Subject: FW: Waddington Old Hall - Query

RE: The proposed floor buildup and underfloor heating at Waddington Old Hall, Waddington.

Drawing Title
Existing Ground Floor Plan

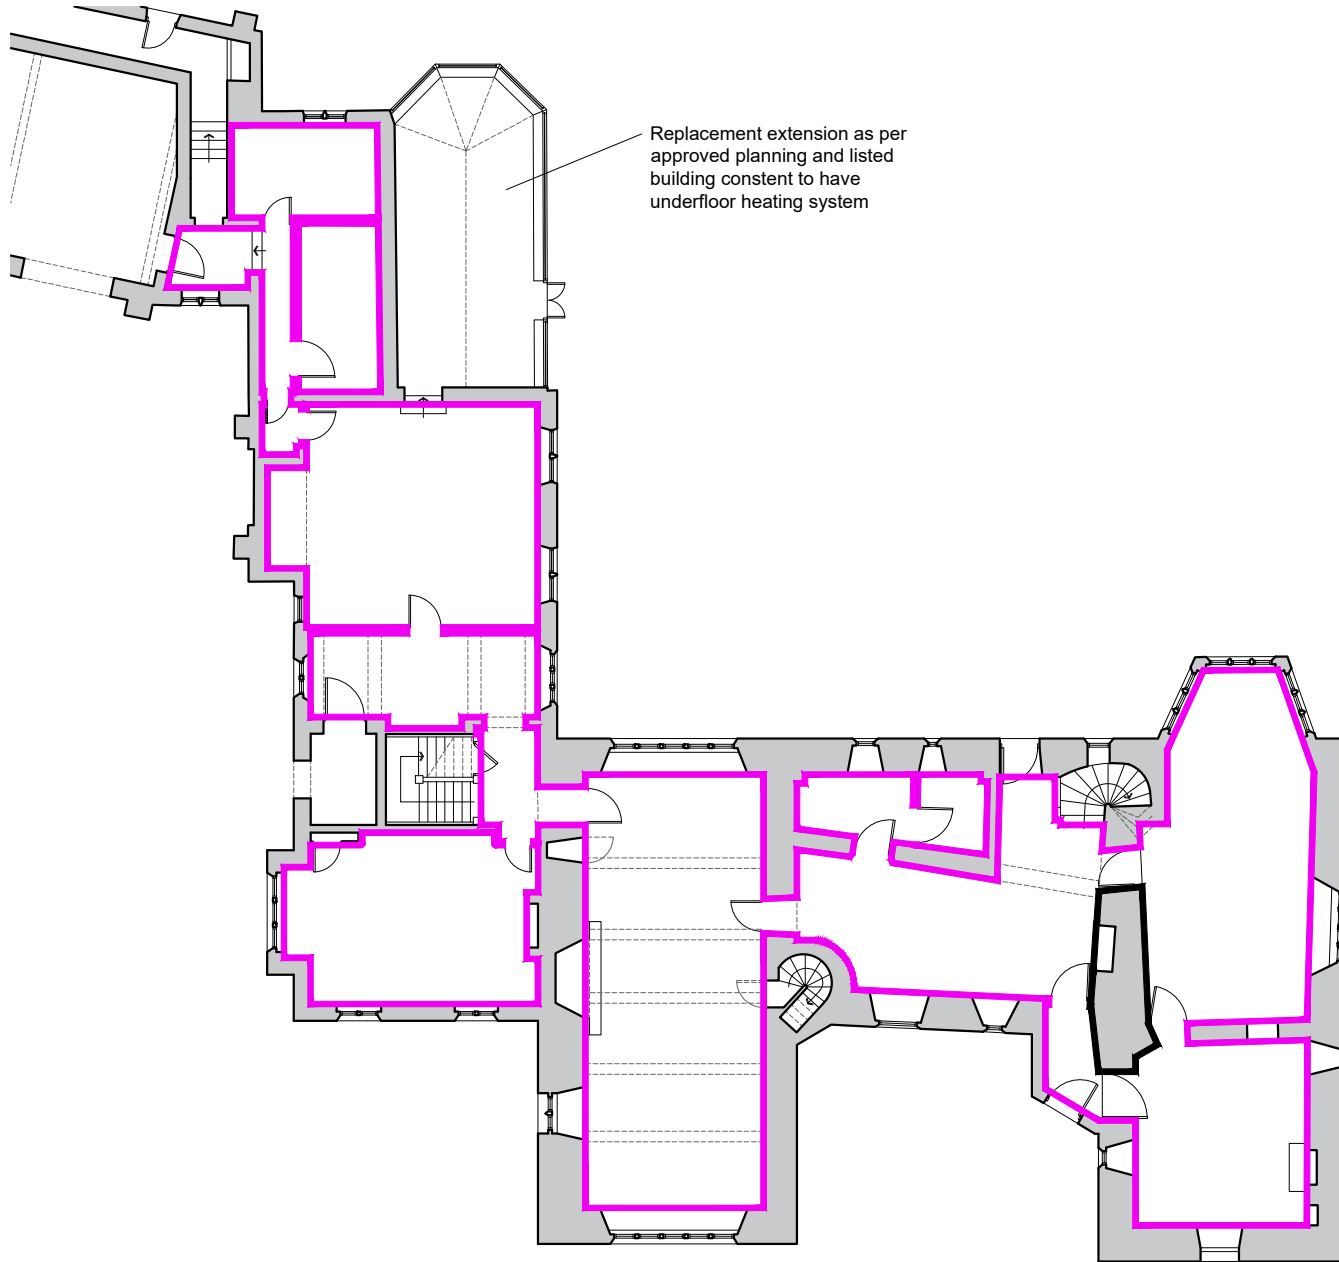
Concern was expressed in the Archaeological report regarding the structural suitability of the reduced thickness of concrete, which in some cases is as little as 50mm. These concerns are valid and have correctly been raised, however we believe that whilst a brand new reinforced concrete slab would be the gold standard from a pure engineering perspective, the proposed works do carry limited and predictable structural risks which when balanced by the need to maintain historical value is likely to justify the proposal. The following paragraphs describe our logic behind this conclusion and our thoughts on the practicality of excavating a small portion of a concrete slab's depth.

With regards to the proposed preparatory works for installation of the underfloor heating in the Monk's Room, Morning Room, Main Reception Hall, Drawing Room, we understand that the proposal is to create a series of saw cuts in the concrete slabs at close centres down to the desired level, and then break out the remaining concrete in between these cuts. Whilst this approach is time consuming and costly, if the cuts are sufficiently close to one another it is likely to form a level base from which to lay the proposed floor build up and avoid breaking through to the materials below.

We can therefore conclude that the current slab is most likely not performing any significant structural function, and therefore any reduction in its depth is unlikely to imply a poor future performance if the materials below the slab are not disturbed (leading to a reduction in compaction). This conclusion is supported by the evidence in the existing Reception Hall and Dining room, where no slab has been provided and it is our understanding that an adequate long term service as a floor has been observed.
